KITITAS COUNTY

MEMORANDUM

SUBJECT: Double K Short Plat SP-16-00005

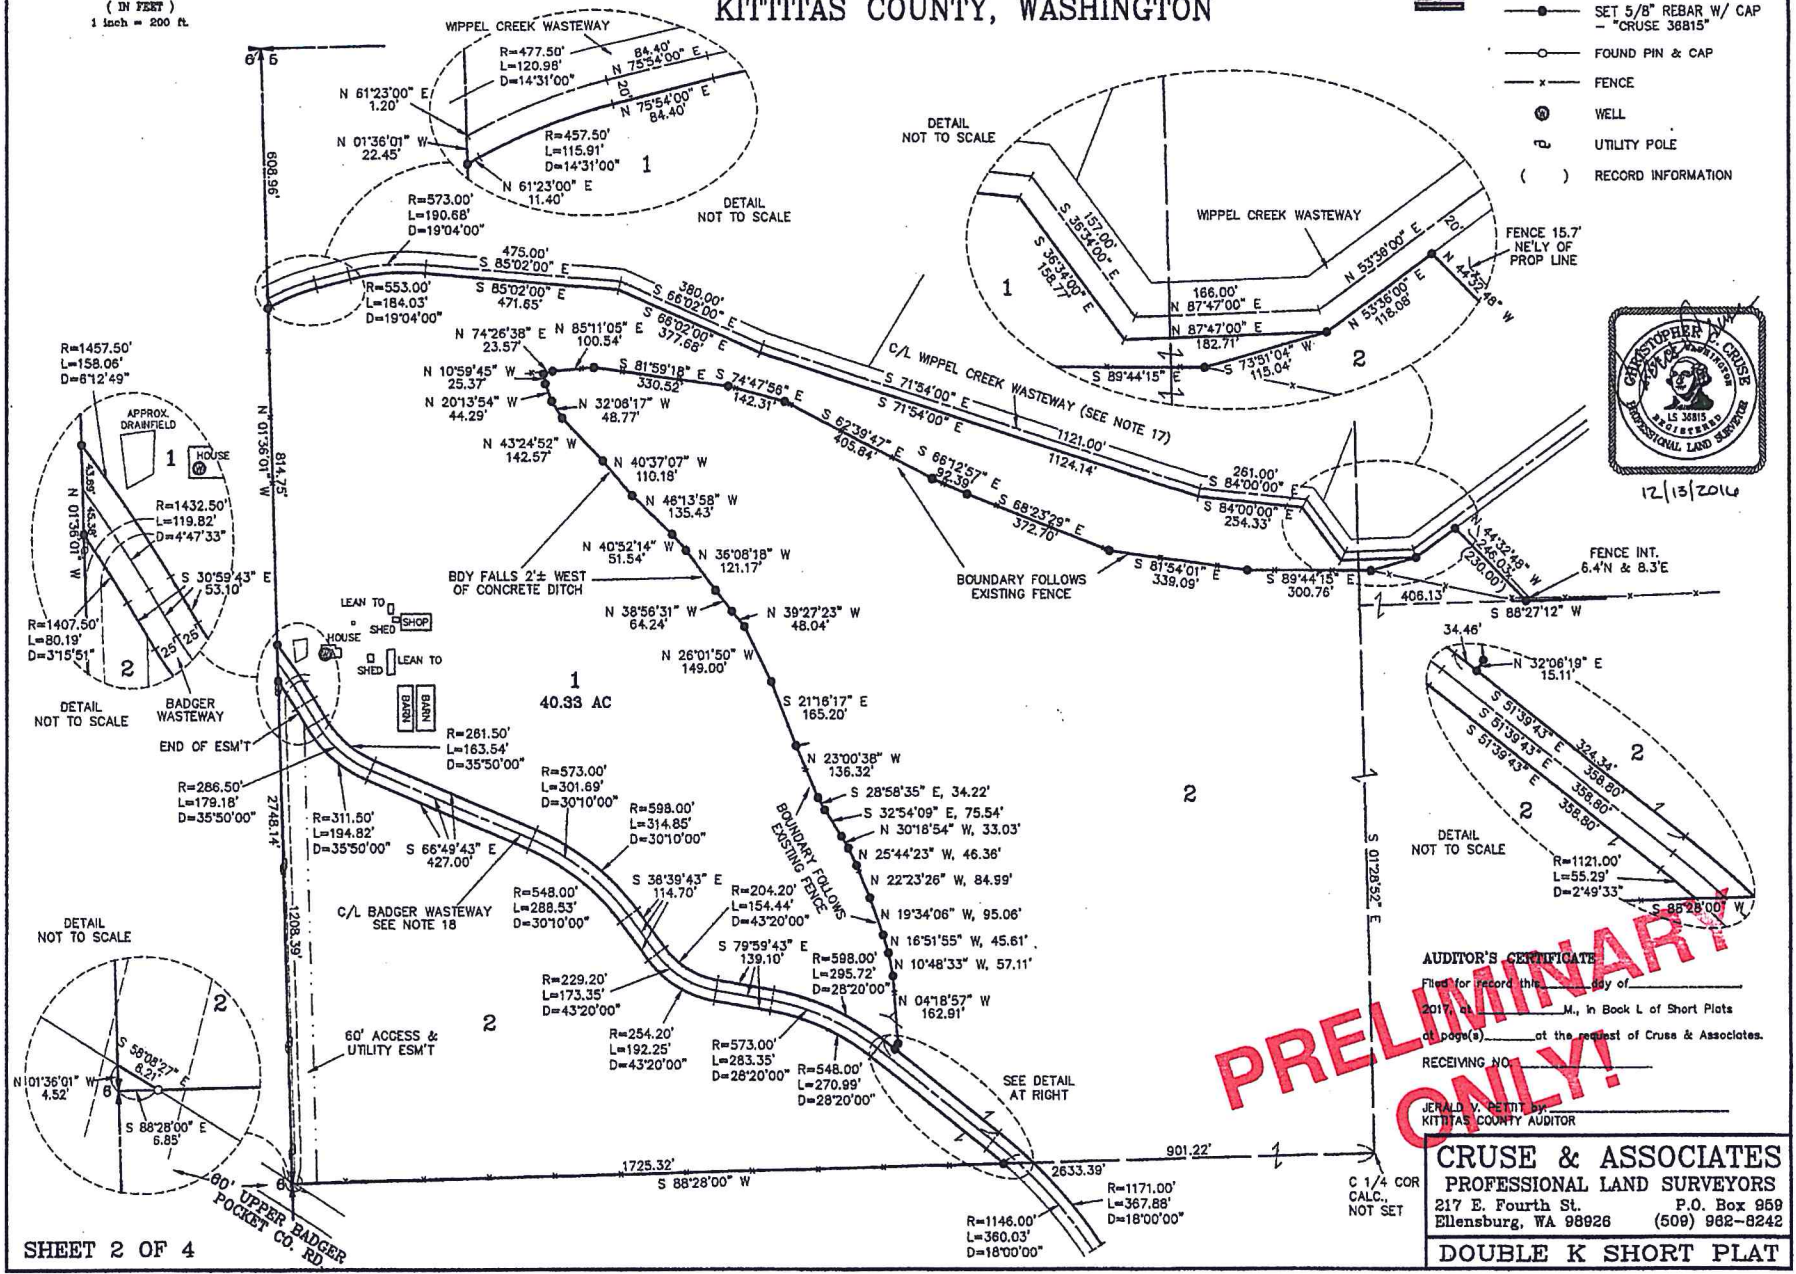
In review of the Preliminary Short Plat documents, the 60' Access & Utility Easement does not show connection with Upper Badger Pocket Road except for an 8' section. The entire minimum joint use easement width of 30' must match up to the access point onto Upper Badger Pocket Road.

- a. New access easements shall be a minimum of 30' wide. The roadway width shall have a minimum width of 12' if the length of the driveway is less than 150', or 16' if the length of the driveway is more than 150'.
